Subject: RE: EP/39/22/PL 29 Tamarisk Way

Subject: EP/39/22/PL 29 Tamarisk Way

Proposed Ground Floor Plan
1469/NA15A
Scale 1:100 at A3 .

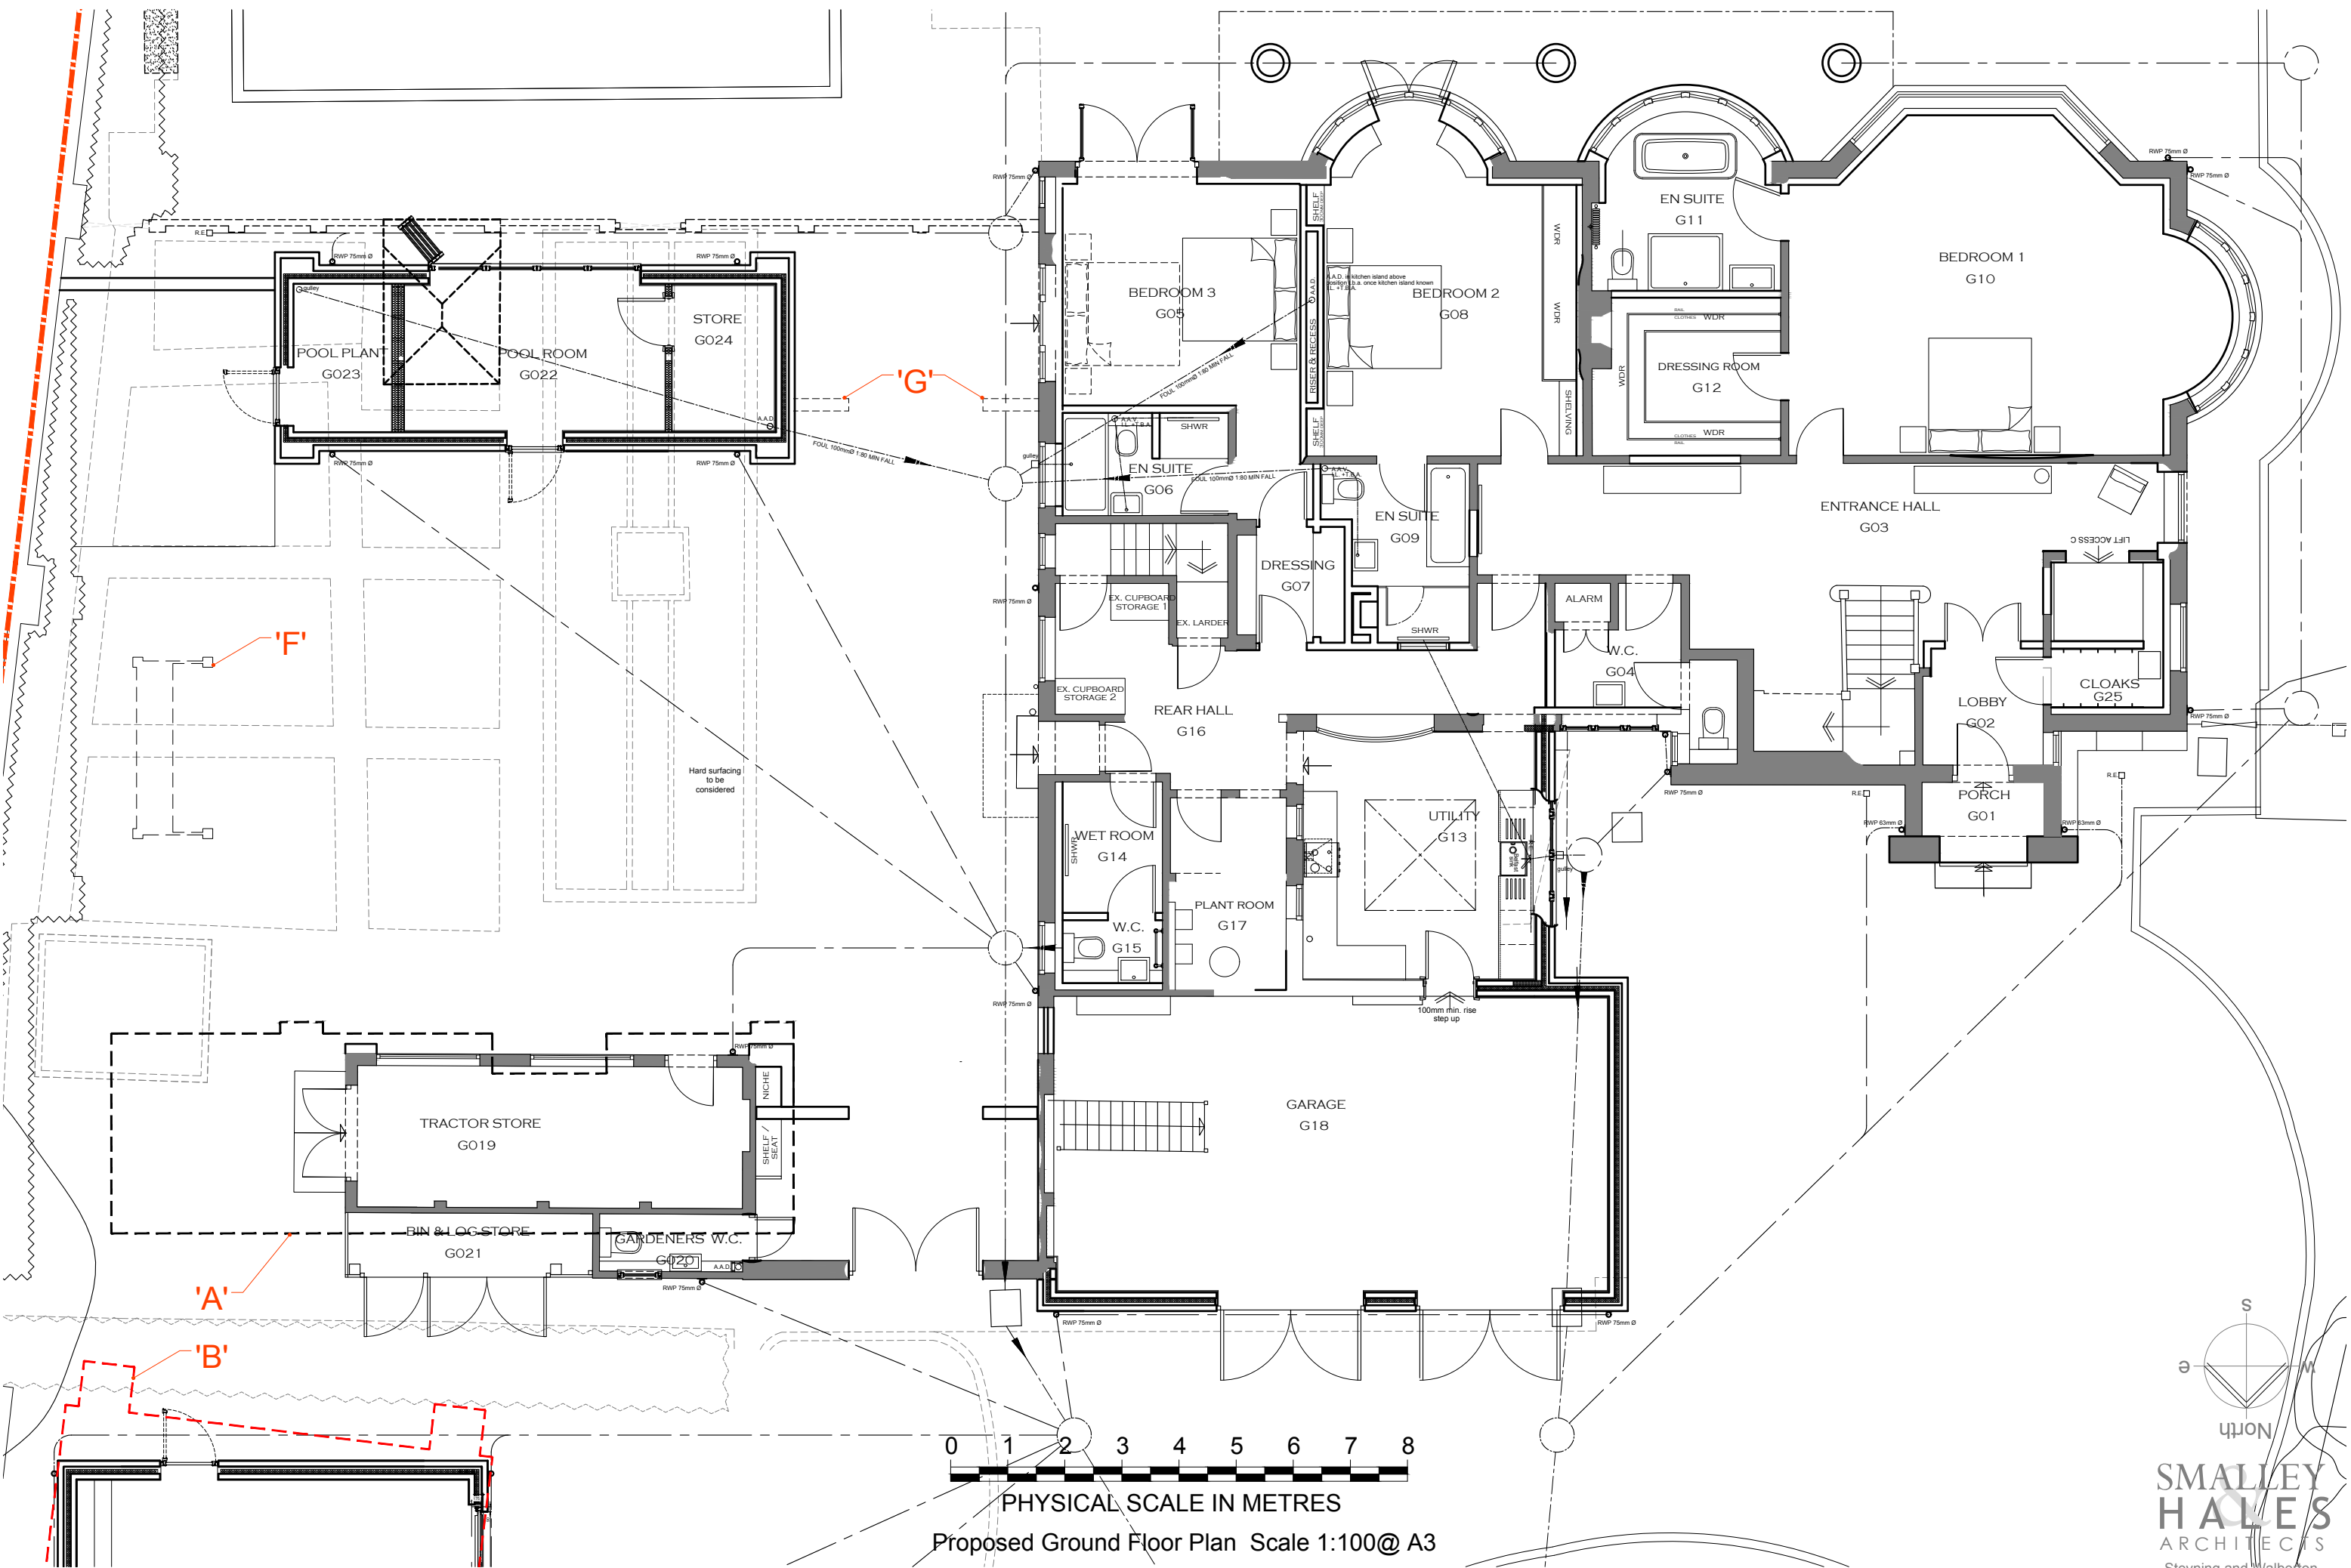
Apologies for the delayed response relating to the above application which was recently transferred over to me. Having now looked through the application documentation and recent correspondence with Obafemi and having had the chance to discuss the case with Juan, we feel that the loss of the eyebrow dormers would have a detrimental impact to the character of the building.

As a Locally Listed Building any alterations are expected to relate sensitively and respect the architectural interest as per Policy HER DM2 of the ALP. As stated above the eyebrow windows form part of the character and as such we seek to preserve these features of interest. I understand that there are difficulties relating to the rainwater gear however, technical matters of design are not a concern for planning, and we would request you seek an alternative method to install the guttering whilst maintaining the special architectural features of the building.

The aspects which we believe you to be referring to are those sections above the windows, identified as 'E' on the proposed plans. Please could you confirm? If so then, as you have acknowledged, we would not be able to provide these design features due to the proposed rain water guttering. This has been explored and unfortunately there is not another method available in providing the guttering without detriment to the visual impact of the building which is considered to be more significant than the loss of the design features to these windows. We would therefore suggest that there is not an alternative method to install the guttering.

The browed eaves were not structural and were part of the thatch roof which the original consent gained permission to remove. The browed eaves are not supported by timber substructure and we therefore cannot replicate such minor protrusions within the tiled roof.

Although the proposed plans seek to remove the browed eaves above the windows, the scheme seeks to retain the eyebrow dormers as previously approved at roof height and ground floor. The eyebrow dormers are considered to be the special architectural features of the building which are capable of being delivered. Unfortunately it is not possible to deliver the browed eaves as part of the tiled roof. This was only possible with the thatch roof.
